MOLE VALLEY DISTRICT COUNCIL

RESPONSE TO GAL'S DRAFT ISSUES TRACKERS

ISSUED ON: 18 AUGUST 2023

18 SEPTEMBER 2023

Predicted 2032 >1 dB Noise Change Footprints – Noise-Sensitive Designated Heritage Assets

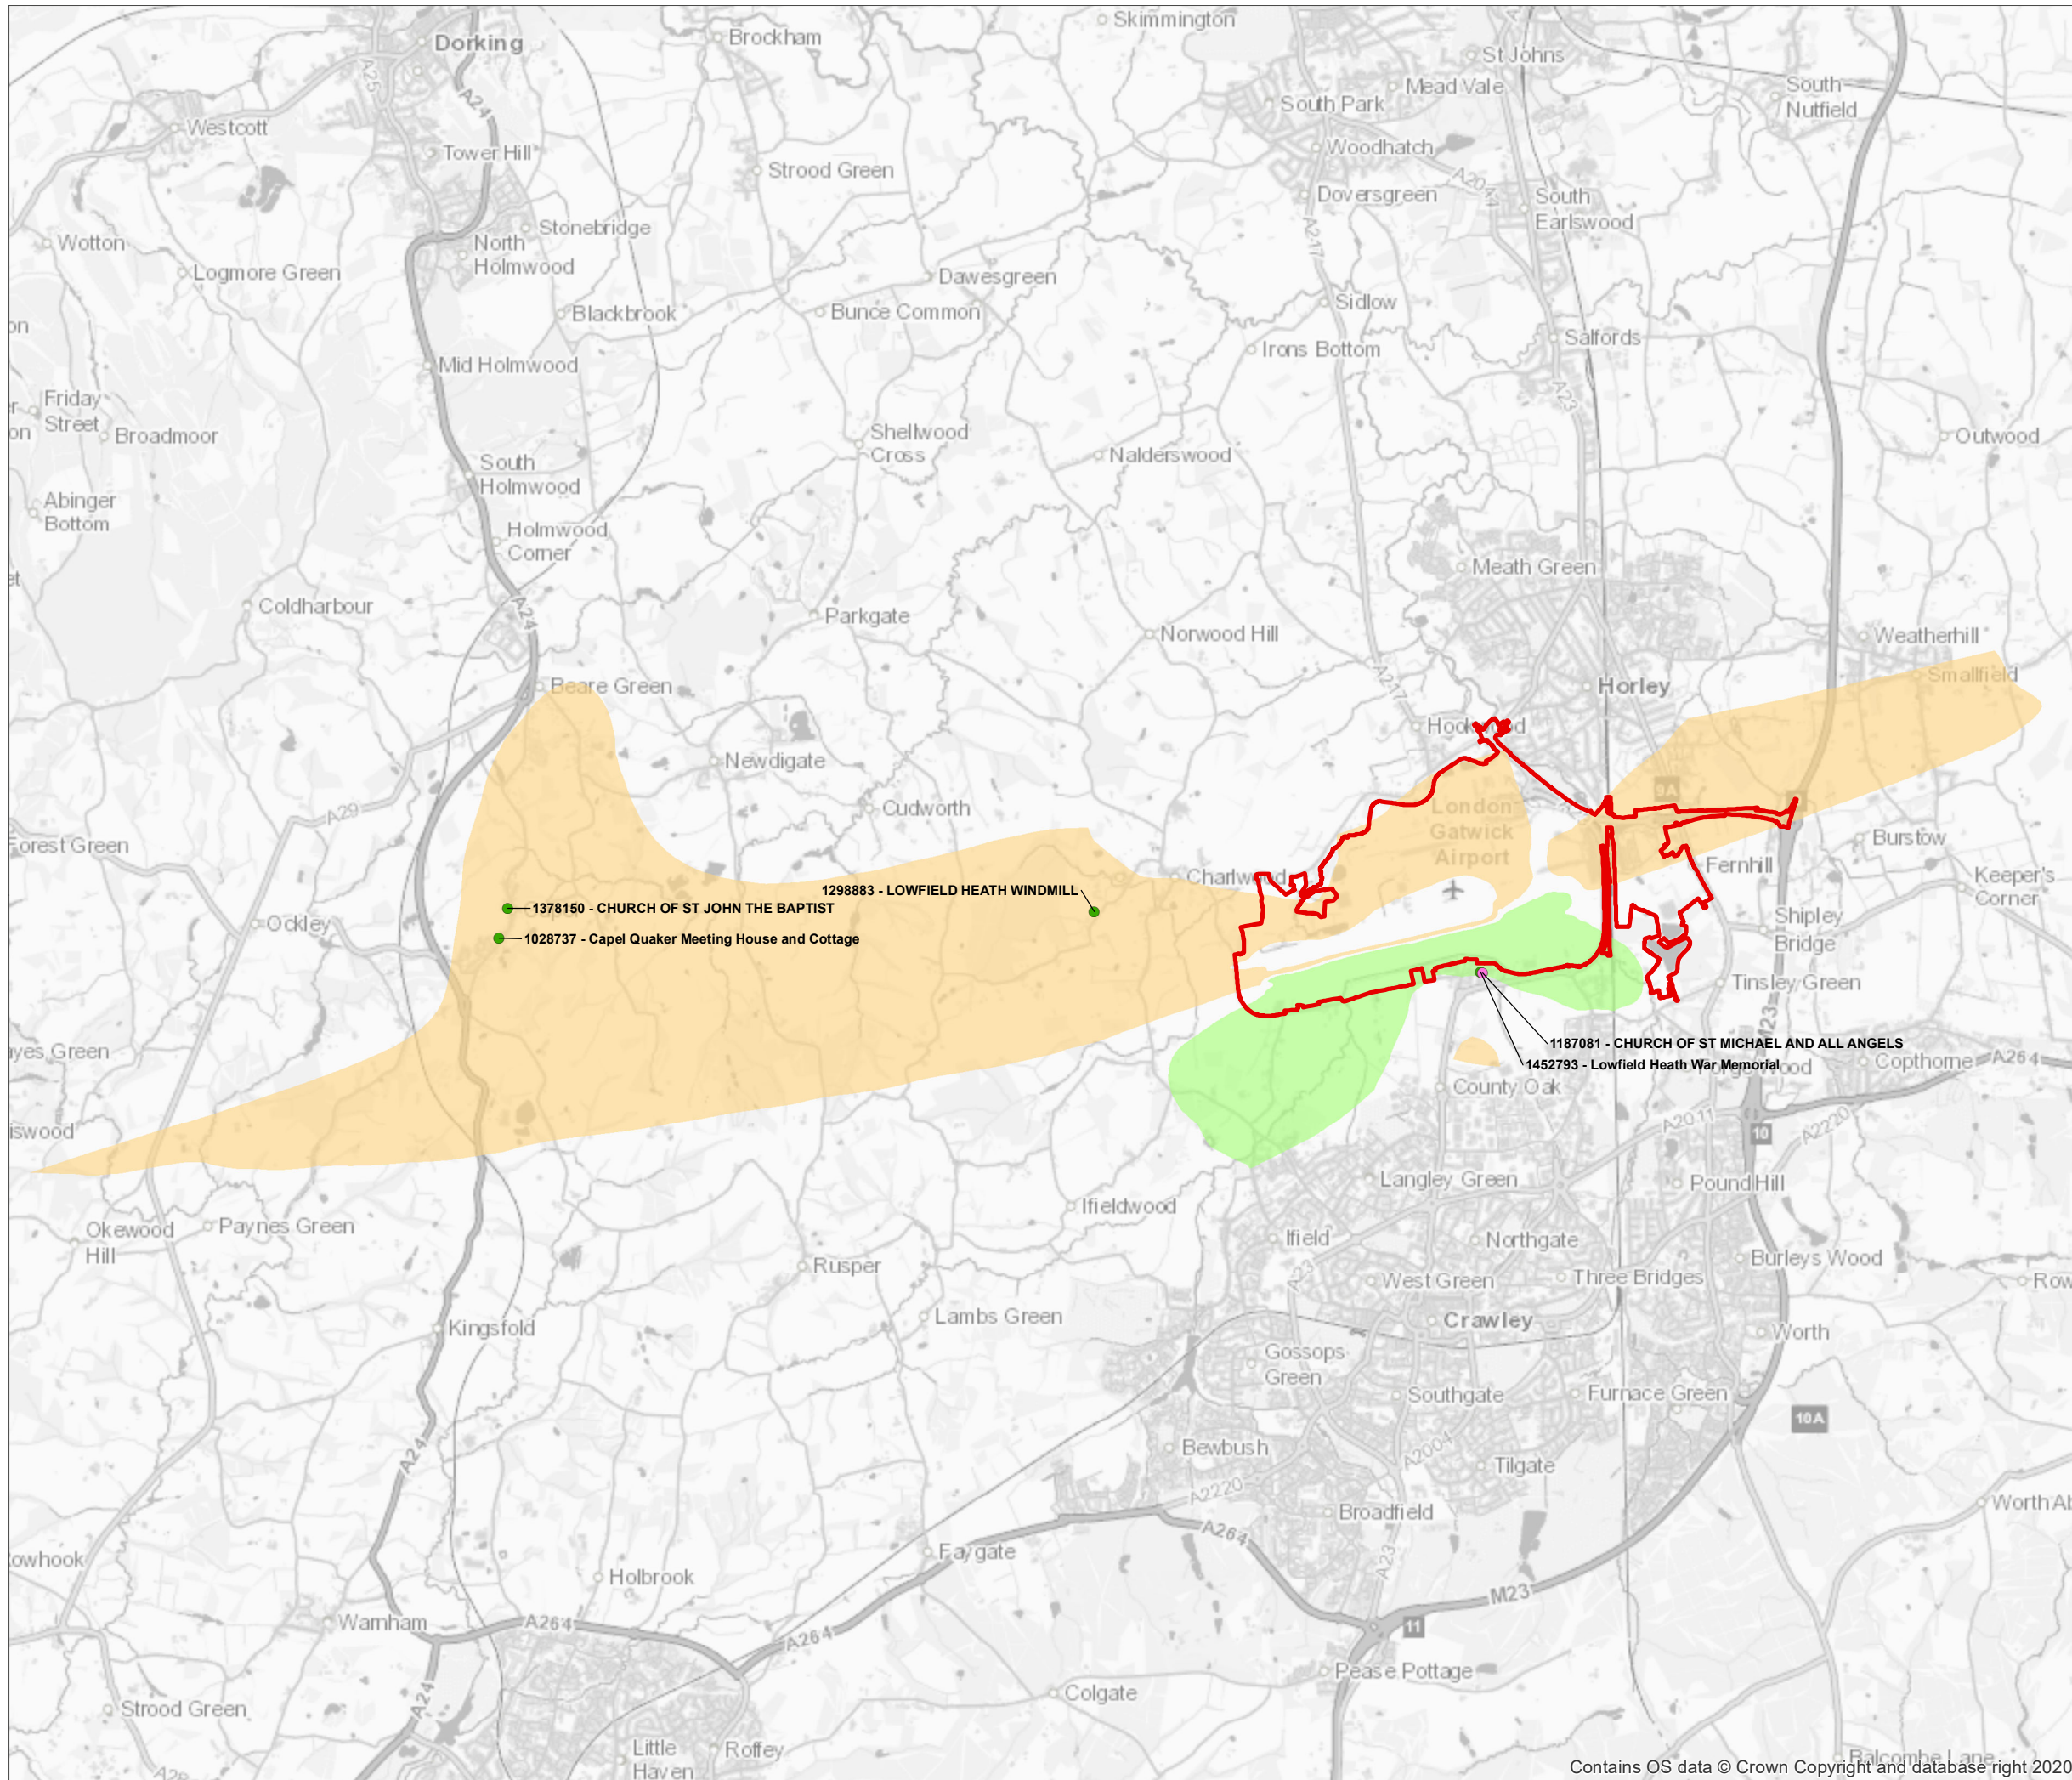
Issue
Heritage implications for air noise on listed buildings and methodology issues. The Council does not agree with GAL's interpretation of Historic England's methodology and considers that GAL should consider the 90 or so heritage assets within our district under sensitivity Category D.
